Applicant: Fernando Leon-Prado

Address: 50 Fernald St.

perm. # 2015-01324

CHECK-LIST AGAINST ZONING ORDINANCE

BUILDING SECTIONS

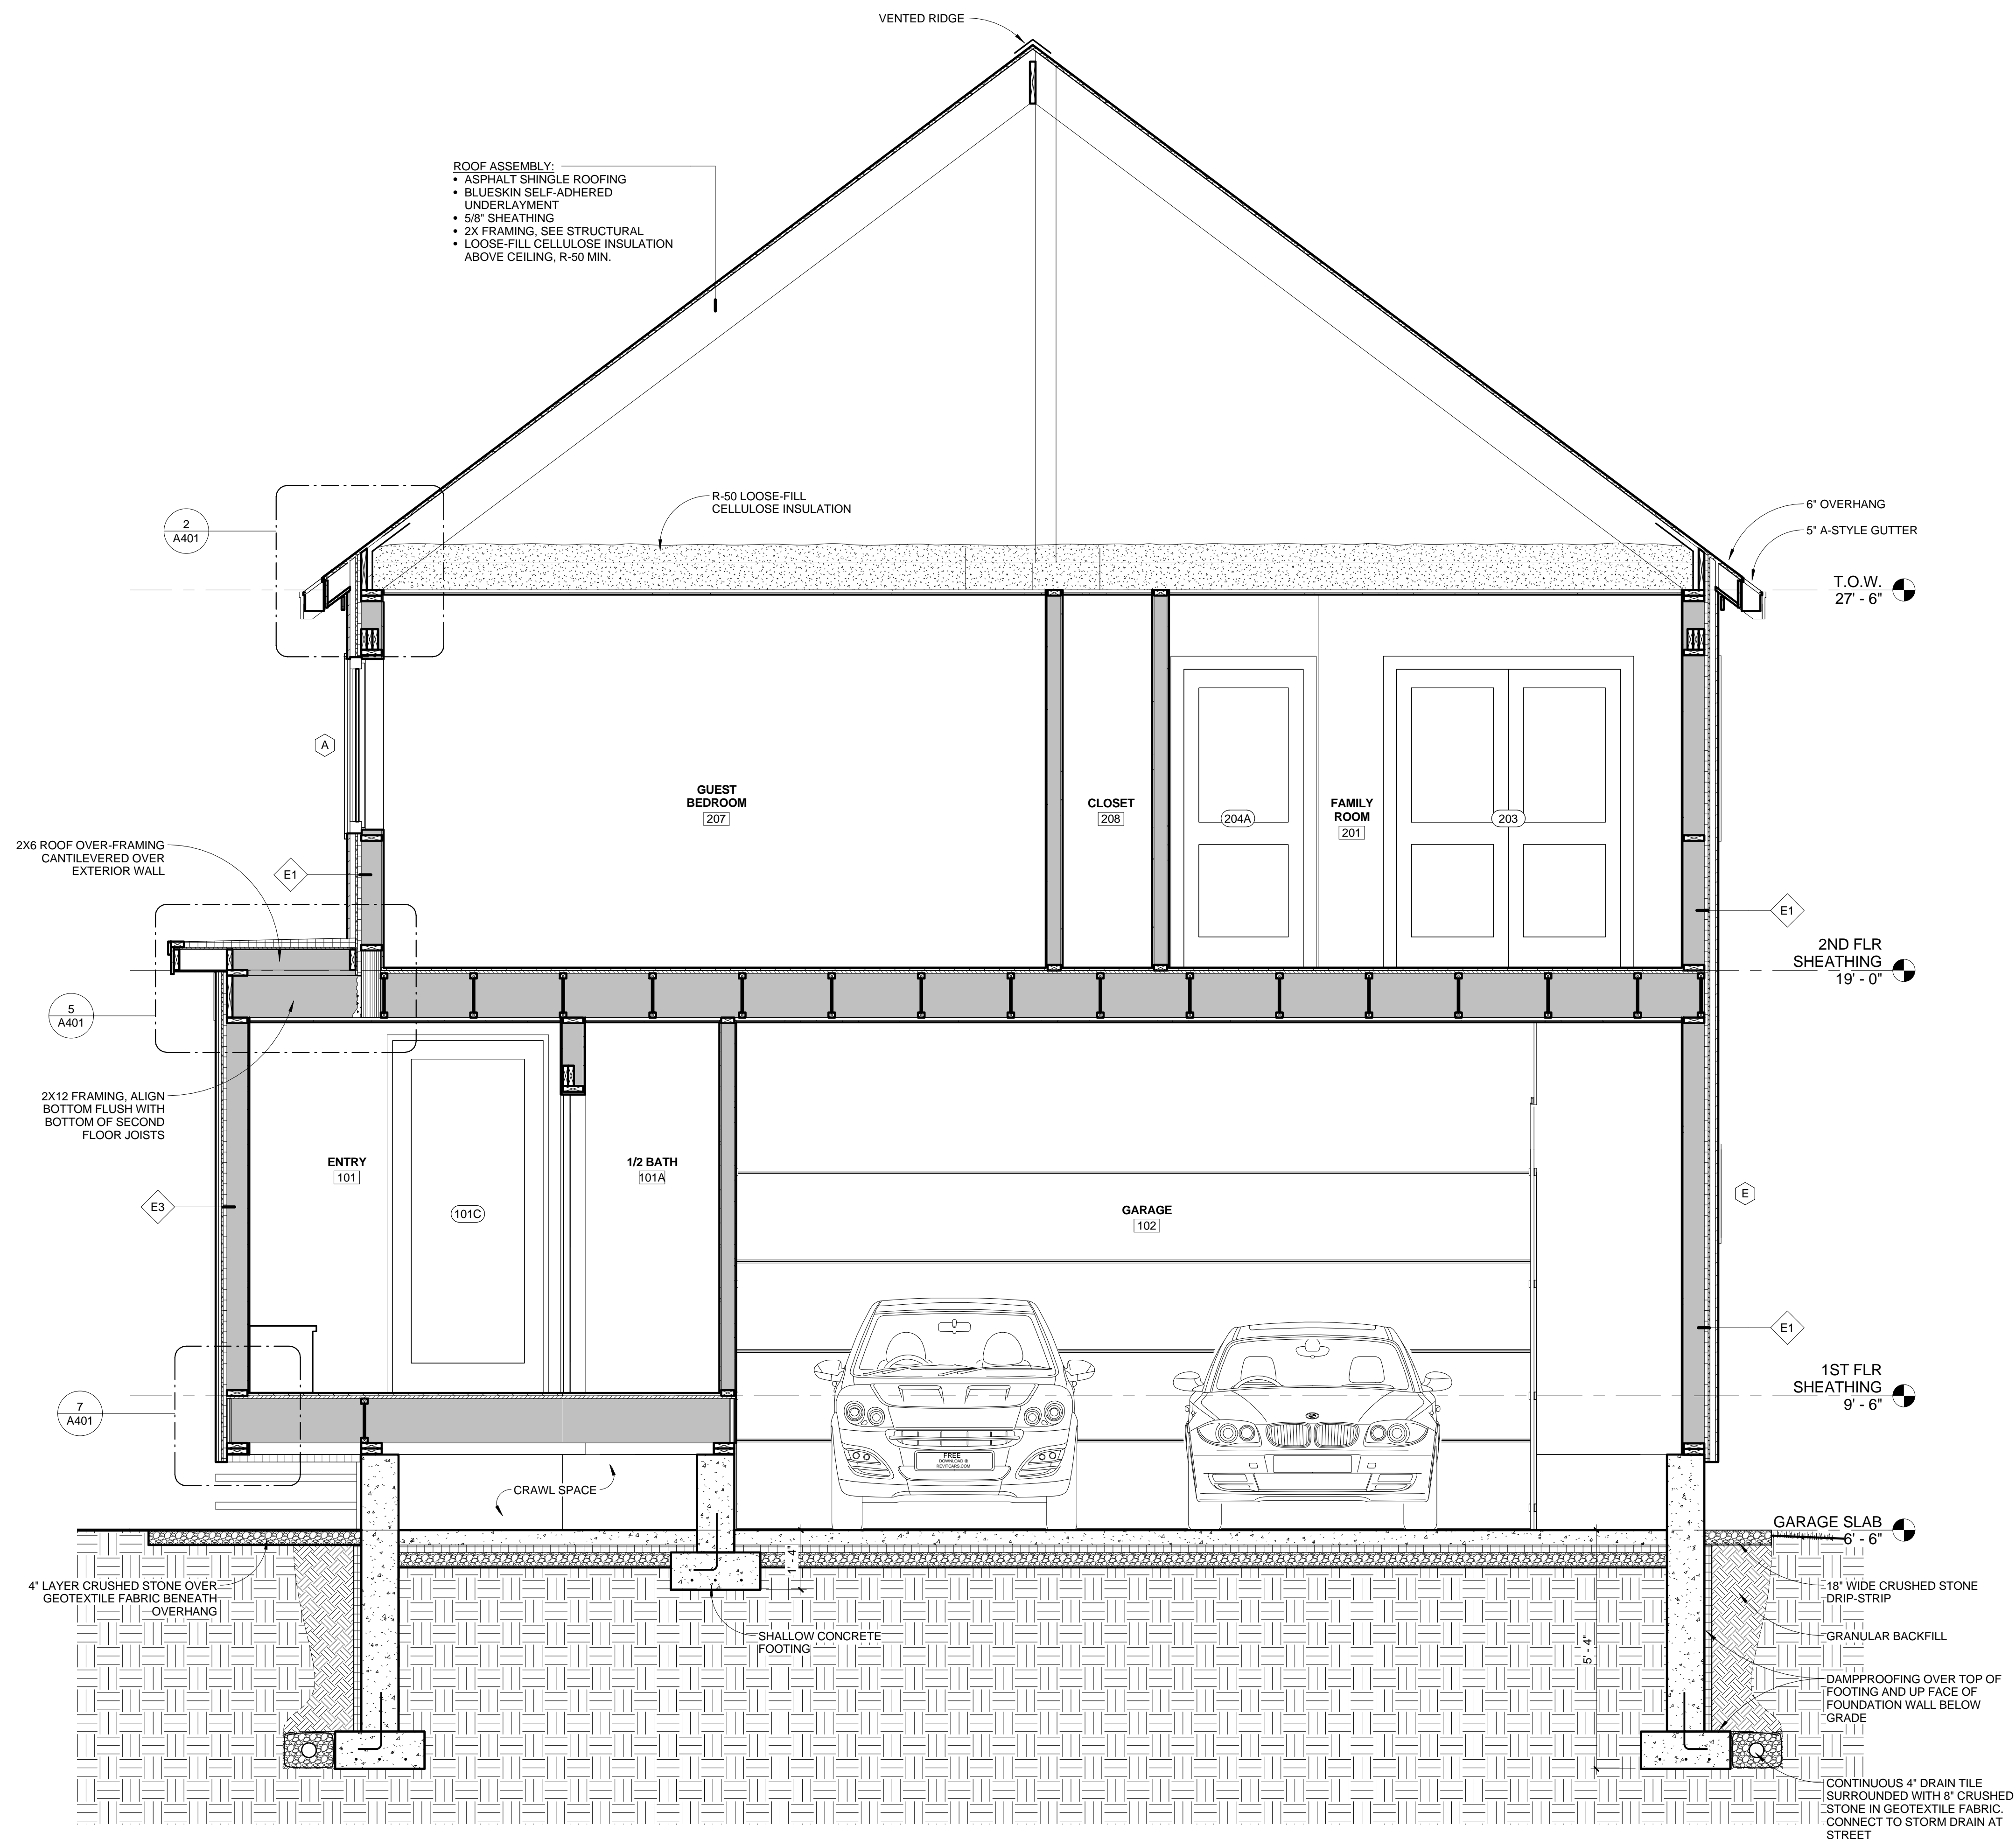
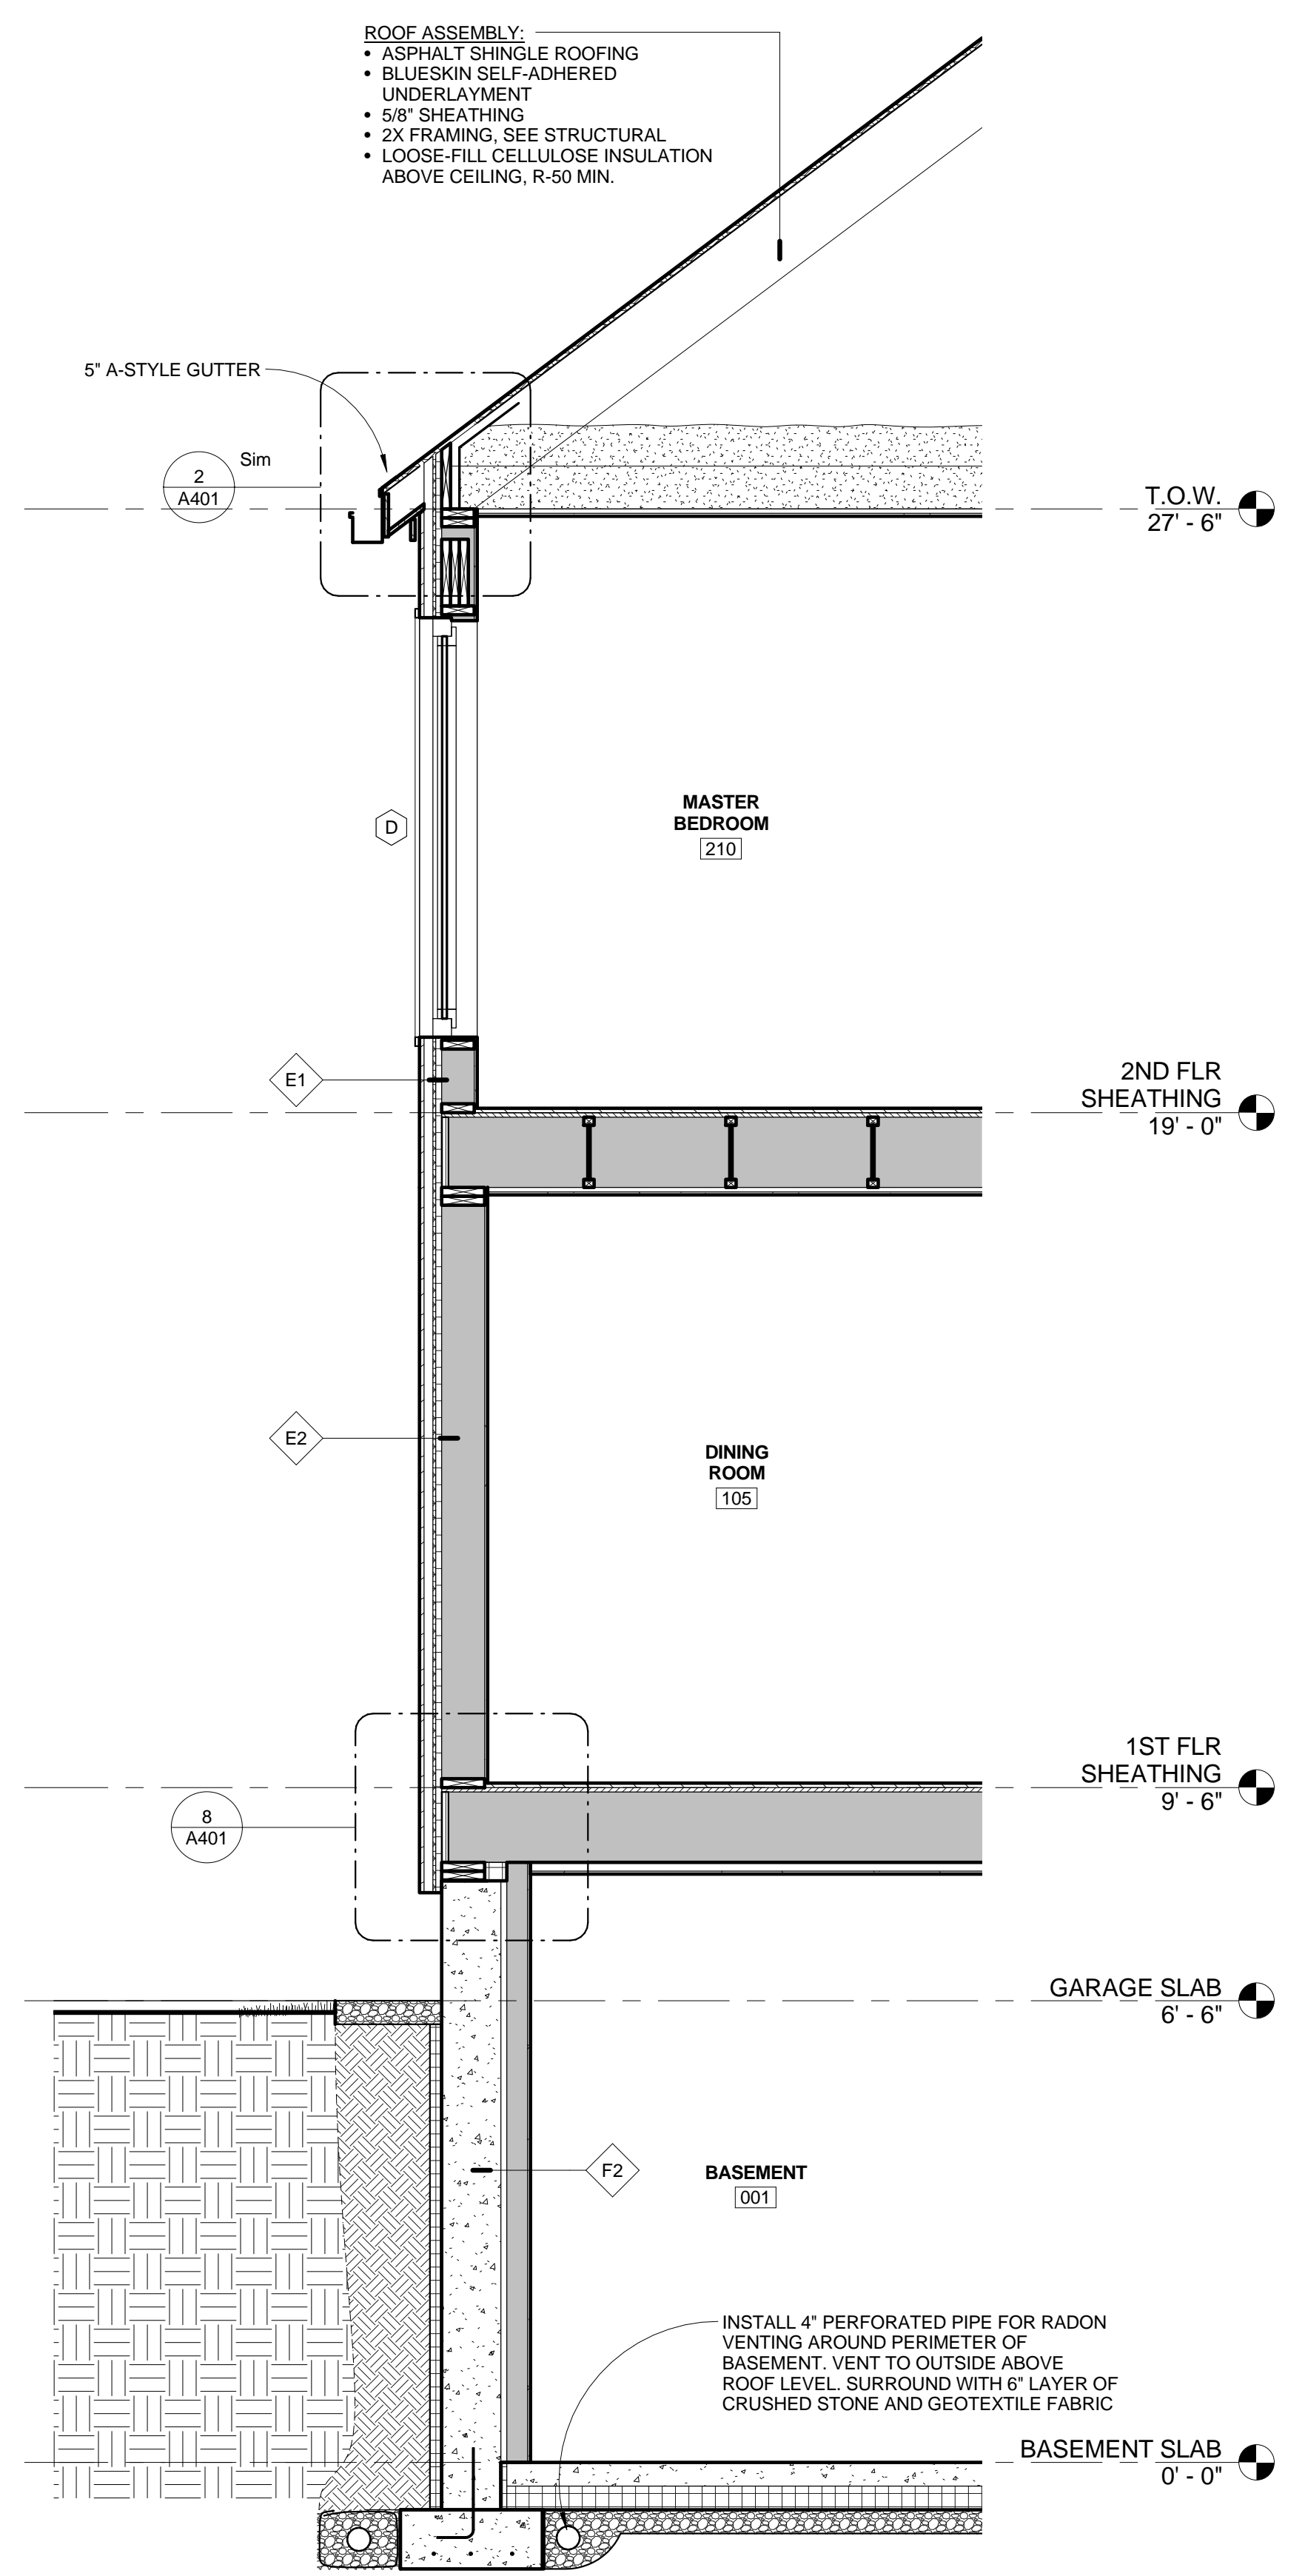
Height - 35' max - midpoint to lowest grade near - scaled, 33.85' (OK)

SITE PLAN
50 FERNALD STREET

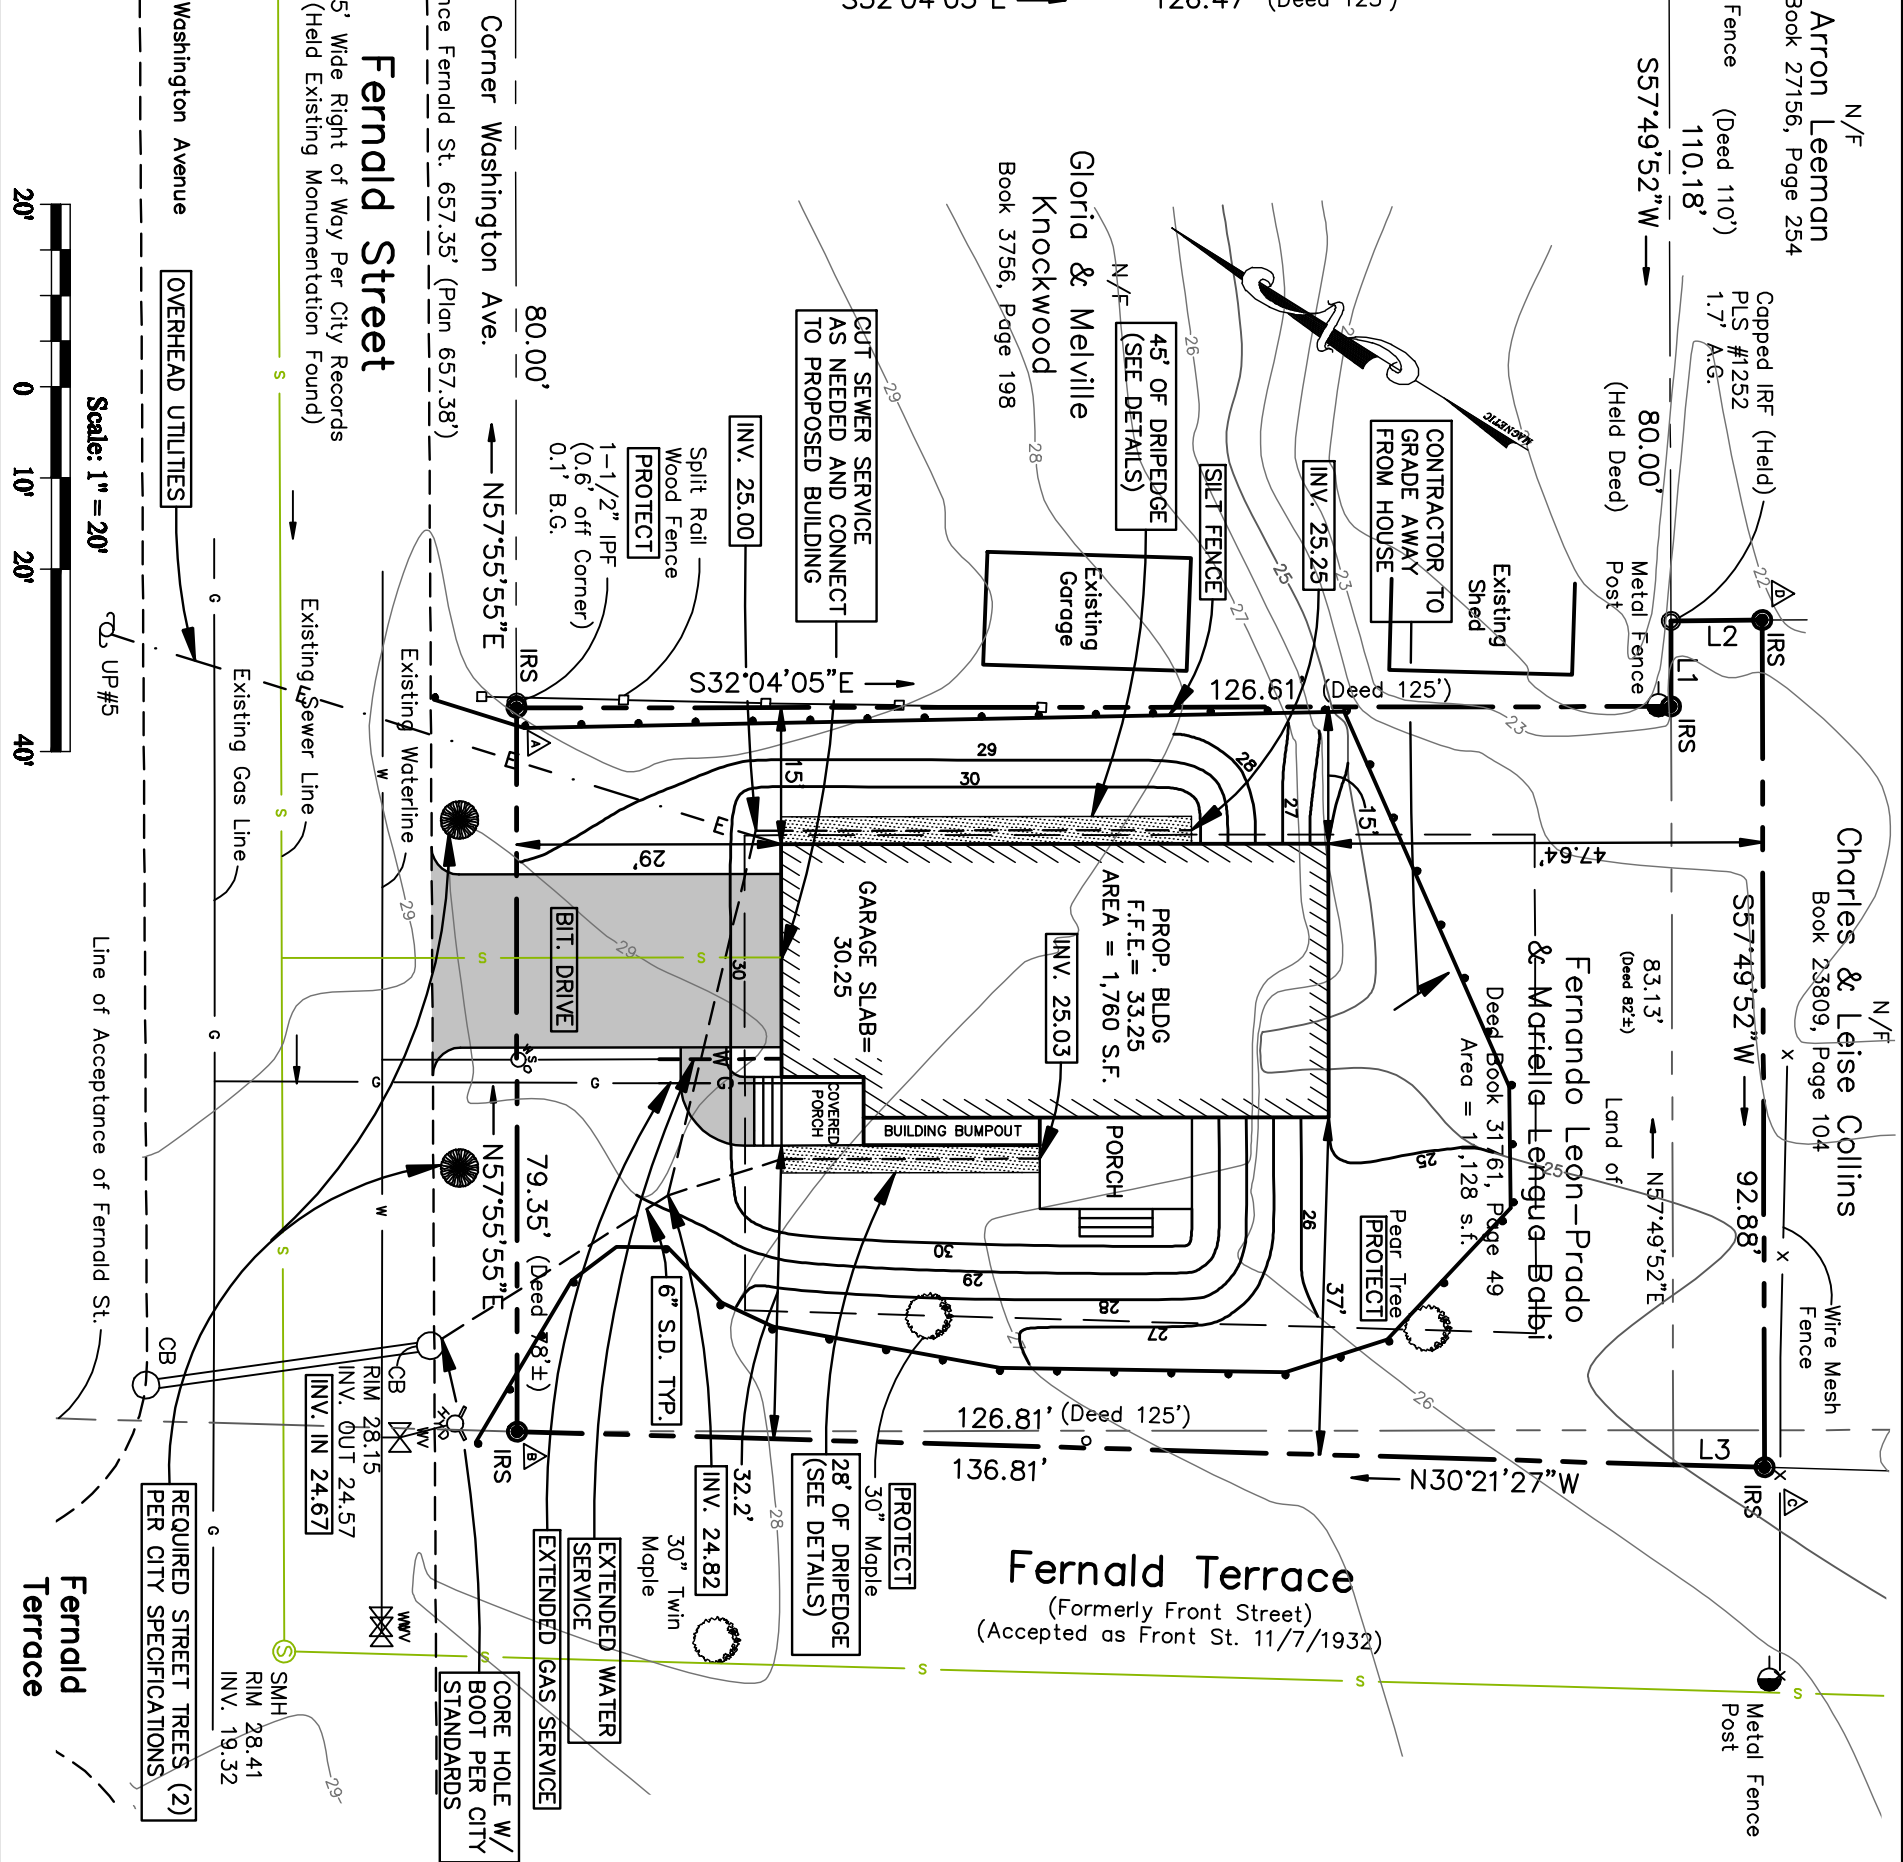
Lot Street Frontage - 50' min. - 79.35' given
- 78.16' scaled (OK)

Front Yard - 25' min. - 25' to front - 25.9' to front steps (OK)

Rear Yard - 25' min - 47.5' scaled (OK)

Side Yard - 2 spaces - 14' min - 15' given on left - OK

Projections -
- 35.9' to house
23.24' to steps off porch - on right (OK)
32.5' to bumpout

Width of Lot - 65' min - 81' scaled (OK)

Lot Area - 6700 sq ft min - 11,128 sq ft given (OK)

Lot Coverage Impervious Surface - 35% = 3,894.8 sq ft

Off-street Parking - 2 spaces required - 2 car garage (in lot 21' x 22.7') (OK)
